Subject: 2025/91202 at location Unit 800, Bretton Park Industrial Estate, Bretton Park Way, Savile Town, Dewsbury, WF12 9BS

Please see ecological commentary below.

Project: Bretton Park Dewsbury		Client: UK Greetings Ltd			00 Rev	19/02/24 Date	Draft for client comment Detail	BP Made	LW Chk'd	LW App'd
Title: Landscape Masterplan & Specification		Drawn: BP	Chk'd: LW	App'd LW						
Drawing Number: PWP 942 001	Revision: 00	Drawing Scale: 1:500 @ A1

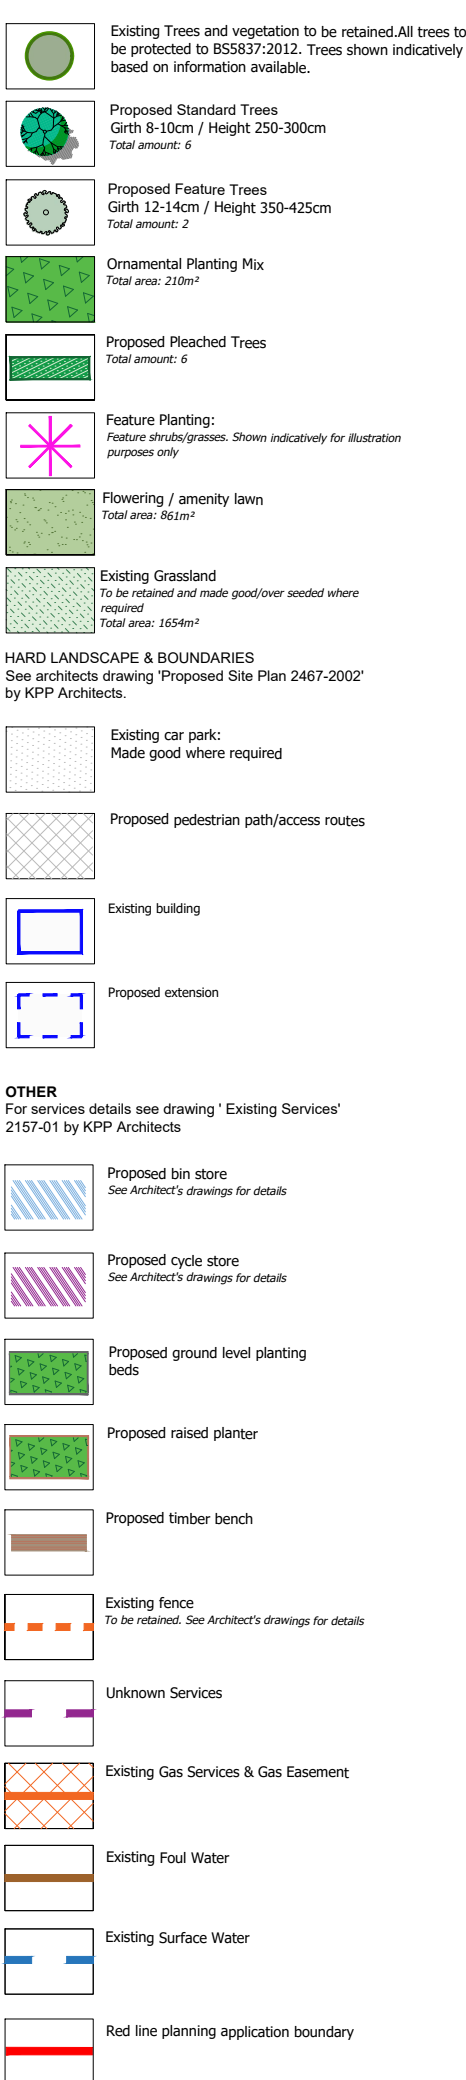
The BNG report and metric are reasonable and acceptable. The site will attain a net gain of 0.12 biodiversity units (21.03% net gain), with a medium distinctiveness habitat through the creation of planters and individual trees; and due to habitat being enhanced with grassland.

We consider that the onsite element of the BNG proposal will not result in significant onsite gain as it would be delivered by. This does therefore not need to be secured for 30 years but could be secured by a simple landscaping condition, if appropriate, to ensure it is provided and maintained for an aftercare period.
